WEST SUSSEX COUNTY COUNCIL CONSULTATION

TO:	Arun District Council FAO: Anita Gardner
FROM:	WSCC - Highways Authority
DATE:	4 December 2019
LOCATION:	The Laurels Dappers Lane Littlehampton BN16 4EN
SUBJECT:	A/166/19/RES Approval of Reserved Matters following Outline consent (Reference A/74/18/OUT) relating to the layout, scale, appearance and landscaping for the erection of 9no two storey dwellings consisting of 2no two bedroom dwellings, 3no three bedroom dwellings and 4no four bedroom dwellings - This is a Departure from the Development Plan.
DATE OF SITE VISIT:	
RECOMMENDATION:	Advice
S106 CONTRIBUTION TOTAL:	n/a

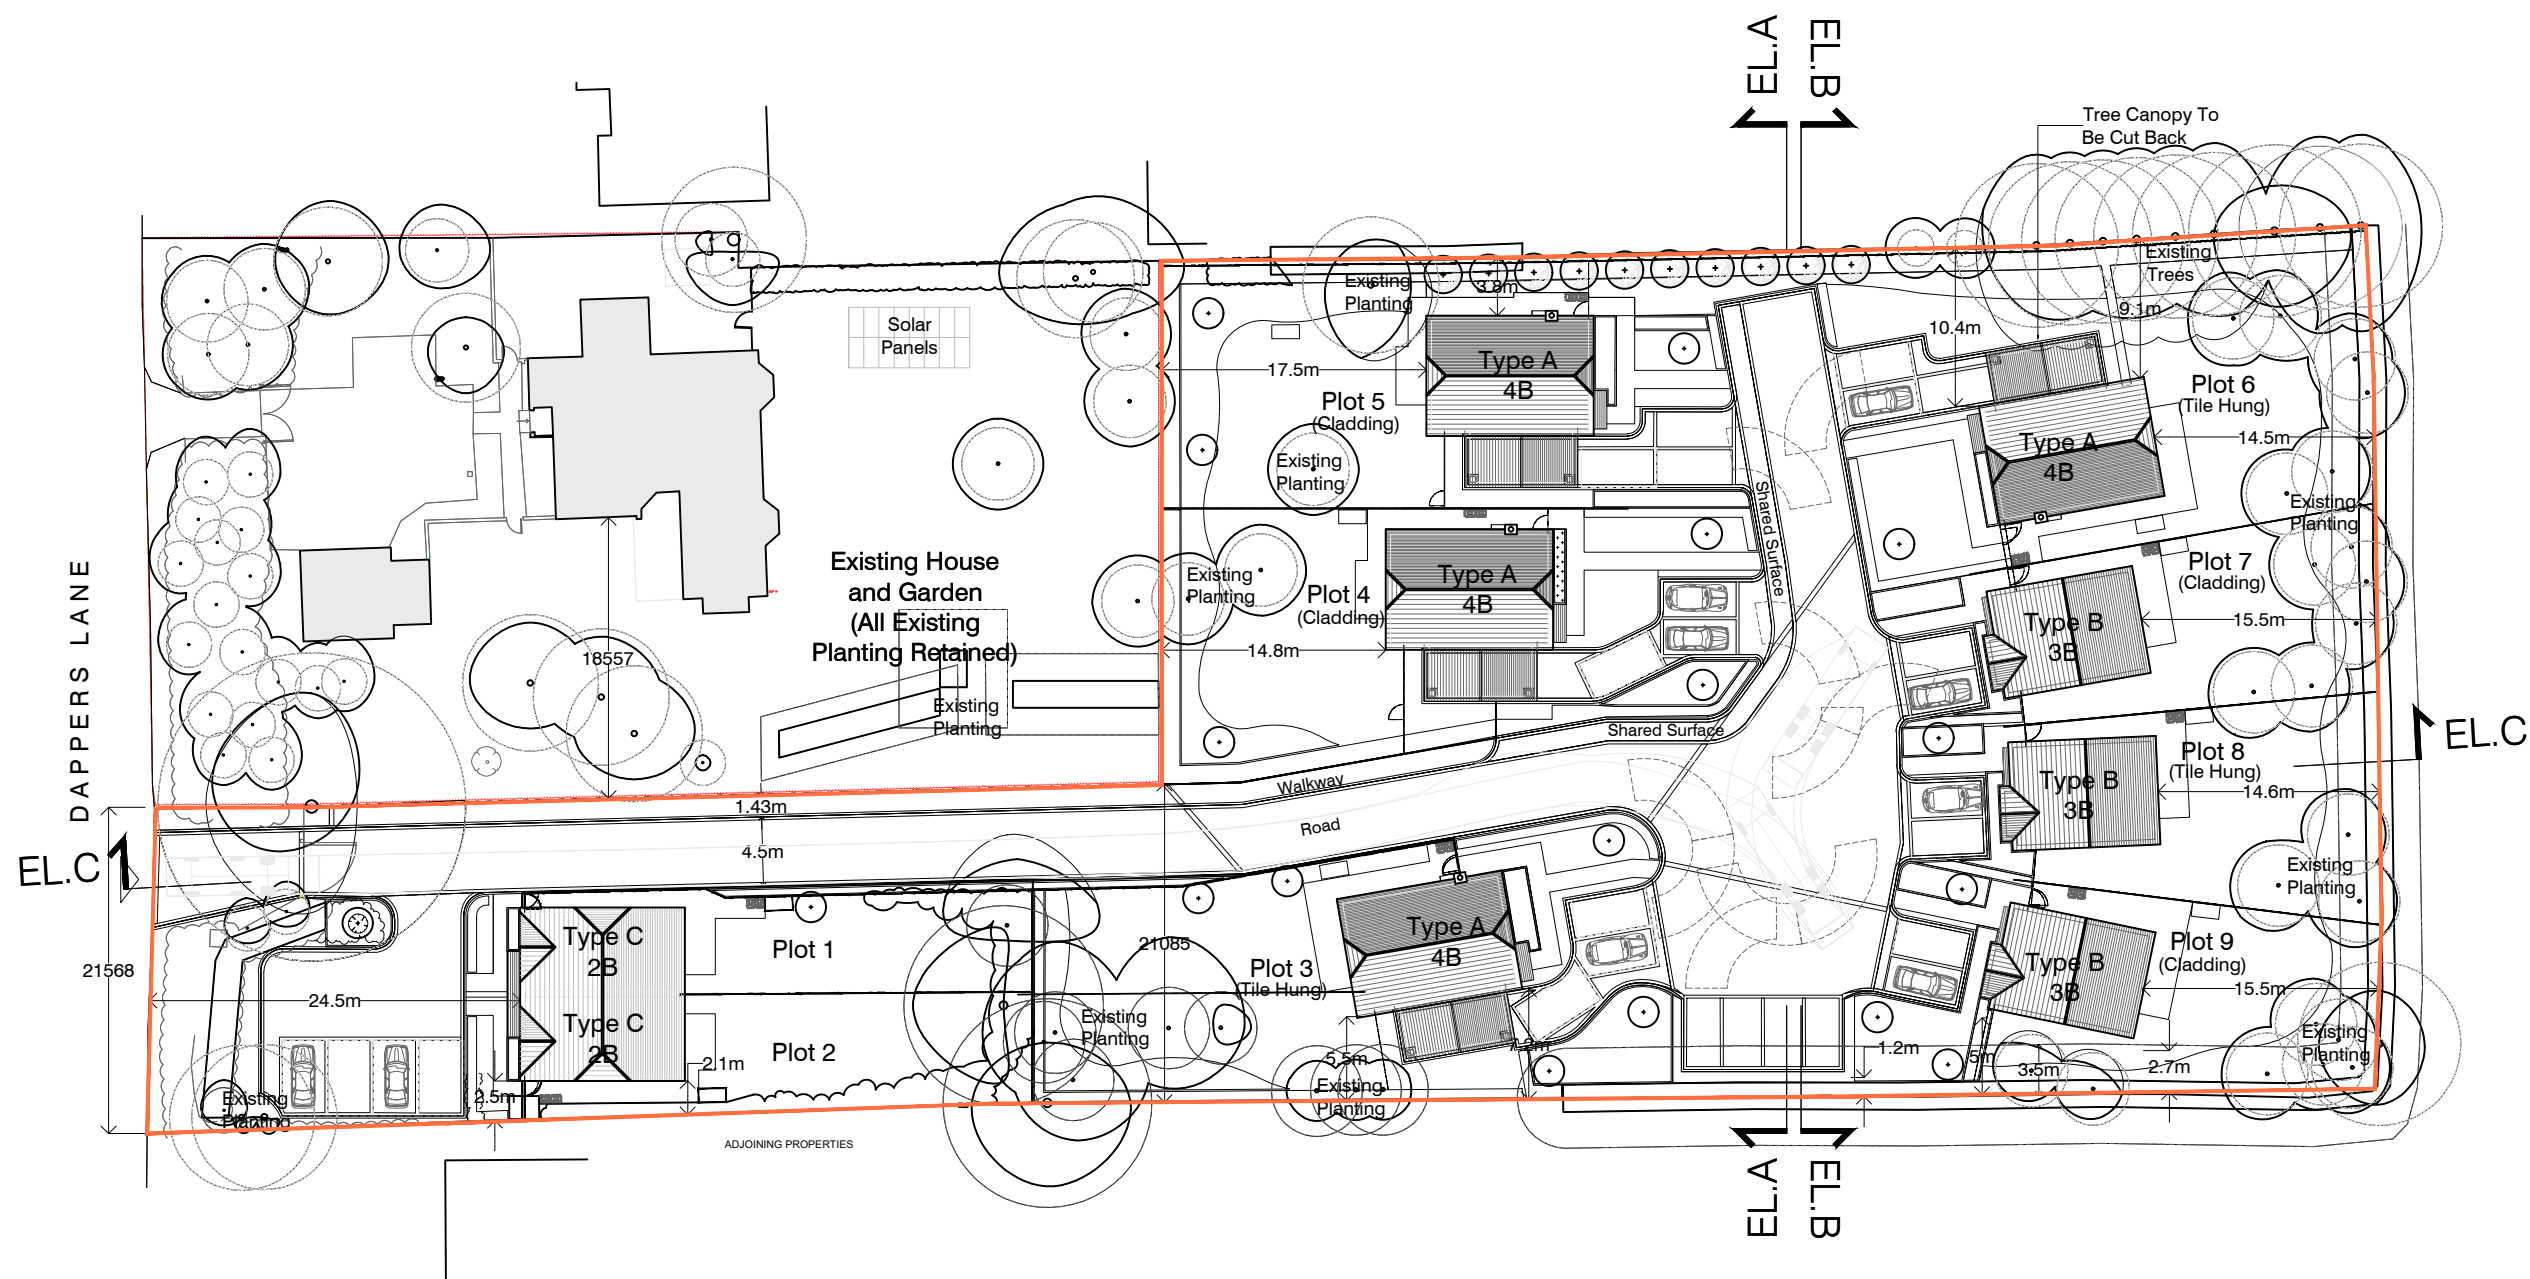
Comments-The application uses the supporting TS from 2018 with what appear to be no changes. Whilst the LHA accept elements such as the swept path diagrams and initial internal layout as outlined in our response from 2018, the LHA's parking standards were revised in August 2019, the applicant would be requested to demonstrate parking in accordance with the latest WSCC parameters.
